FINDINGS OF FACT Iron Mountain Short Plat (SP 06-129)

RE: Iron Mountain Short Plat (SP-06-129)

TO: Dan Valoff, Community Development Services
FROM: Christina Wollman, Planner II *W*
DATE: January 31, 2007
SUBJECT: Iron Mountain Short Plat

IRON MOUNTAIN SHORT PLAT  
PART OF SECTION 1, T. 19 N., R. 15 E., W.M.  
KITITAS COUNTY, WASHINGTON

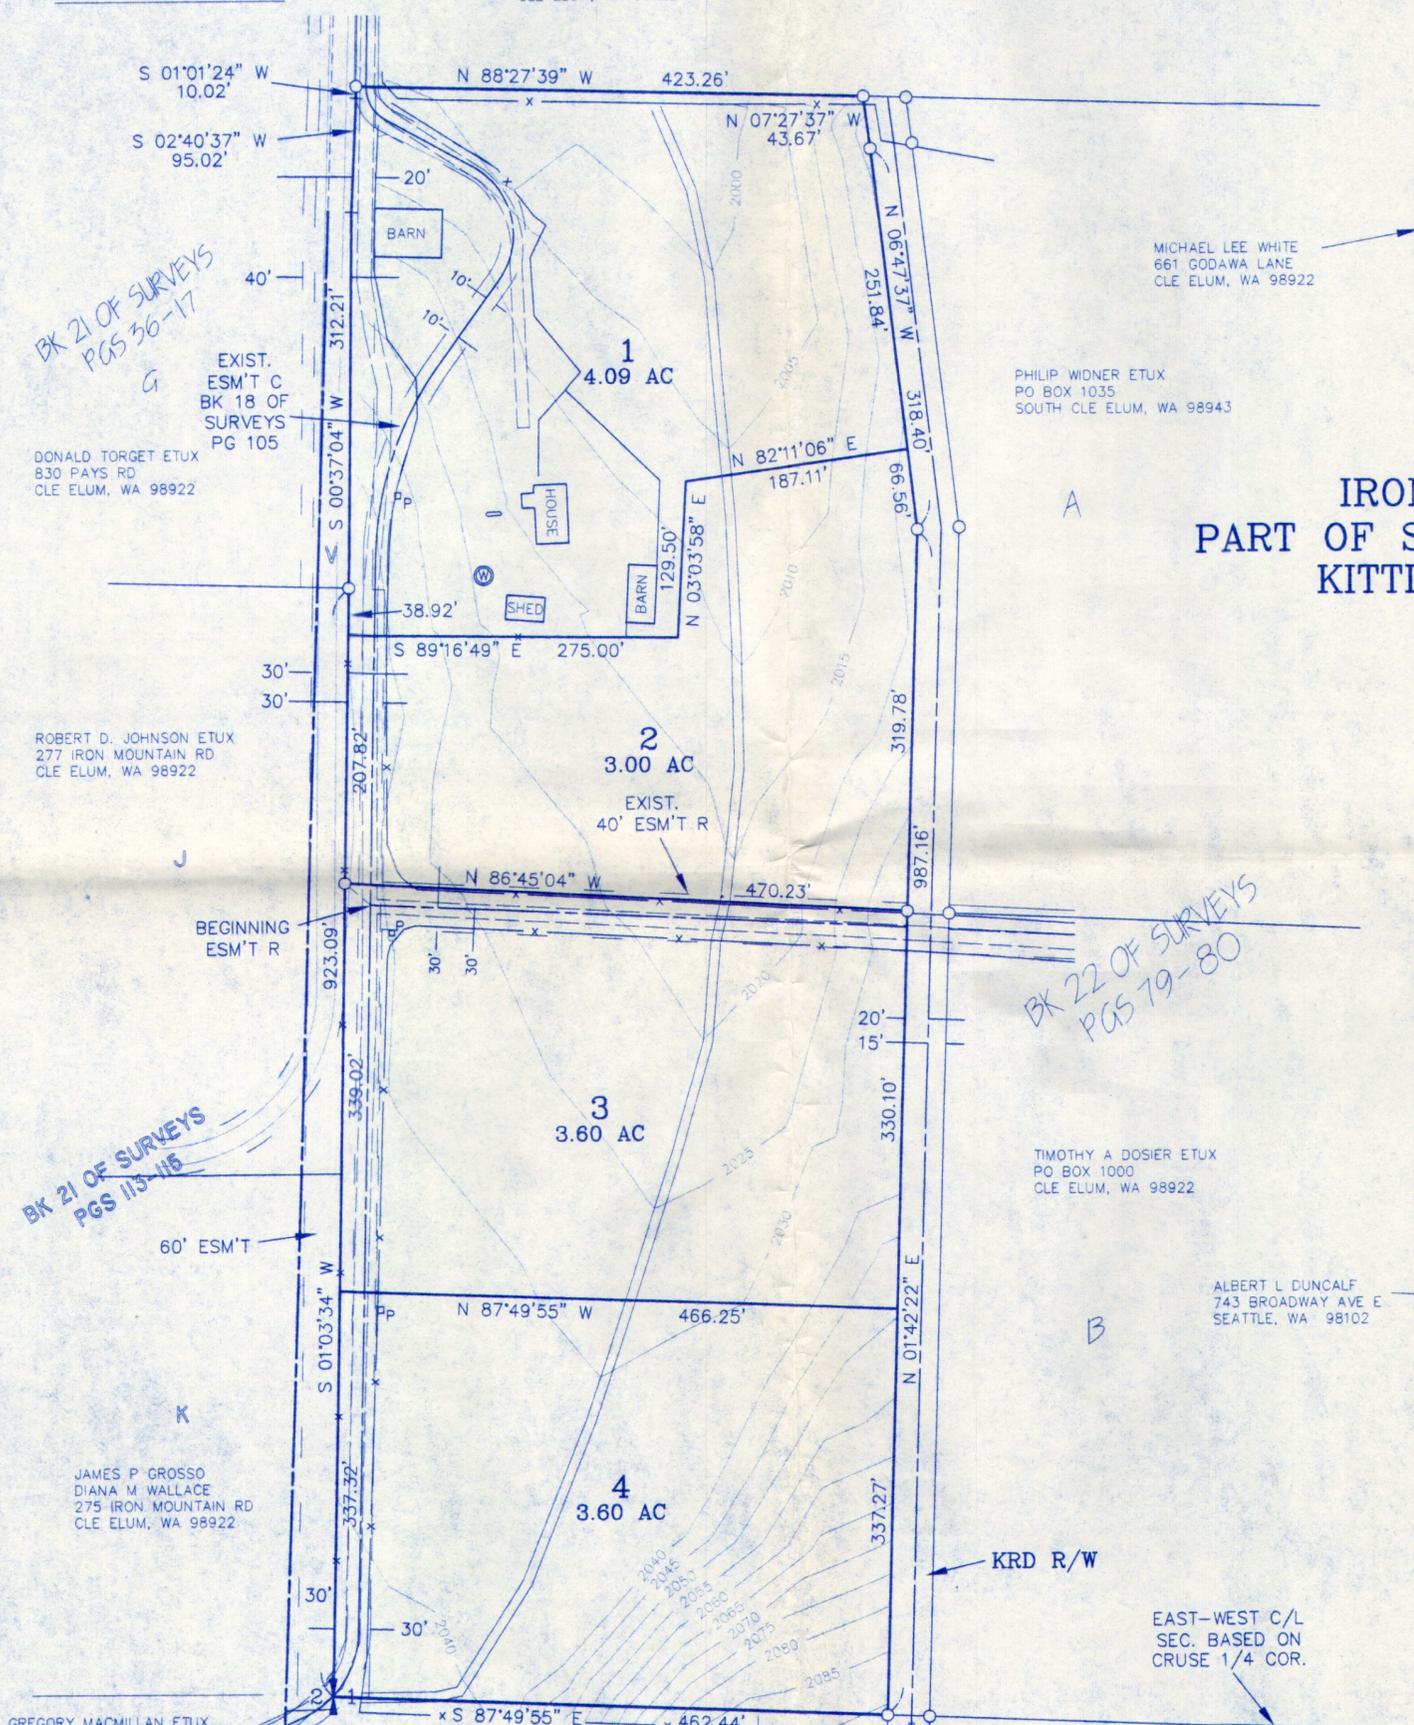
1. Both sheets shall reflect the short plat number SP-06-129.
2. All future development must comply with International Fire Code (IFC) and appendices.
3. All Kittitas County road standards must be met. Attached you will find comments from Kittitas County Public Works. Please contact Christina Wollman at 962-7051 regarding all road standards and access questions.
4. Attached you will find comments from Kittitas County Environmental Health. Please see those documents for required plat notes and information on issues needing completion before final approval of this short plat.
5. Submittal of a Certificate of Title (Title Report) with the final short plat mylar.

1. Private Road: The applicant has applied for and received approval for a variance request from the required 60' easement requirement as identified in the current Kittitas County Road Standards for low-density private roads. The following are conditions of the variance request and shall be applied as conditions of this short plat:

It shall be the applicant's responsibility to secure a continuous and common 60' wide ingress and egress easement for the remainder of Iron Mountain Road that serves the subject property. The 60' wide easement shall be required from the point at which the existing 30' easement, cross the section line, east, into section 2, then from that point, south, to a point at which it serves parcels 19-15-01000-0004 (7.09 Acres) and 19-15-01000-0033 (20.00 Acres) as required for access to the proposed development. The applicant shall improve the existing road to a minimum of 20' traveled way width with 1' gravel shoulders, as required by Fire Code and current Kittitas County Road Standards. This can be accomplished by either widening the existing road with gravel, compacted to 95% and able to support a minimum load of 75,000 lbs as needed for Fire Apparatus or to widen the existing paved driveway to a 20' paved traveled way width with 1' gravel shoulders, compacted to 95% and able to support a minimum load of 75,000 lbs as

3. Cul-de-Sac: Permanent deadend streets shall have a turn-around having an outside right-of-way easement diameter of at least 110' (55' radius) at the closed end. See Kittitas County Road Standards, 9/6/05 edition.

- a. Plat note #9 shall be removed.
 - b. "Entire private road shall be inspected and certified by a civil engineer licensed in the State of Washington specifying that the road meets Kittitas County Road Standards as adopted September 6, 2005, prior to the issuance of a building permit. Any future subdivision or land use action will be reviewed under the most current road standards."
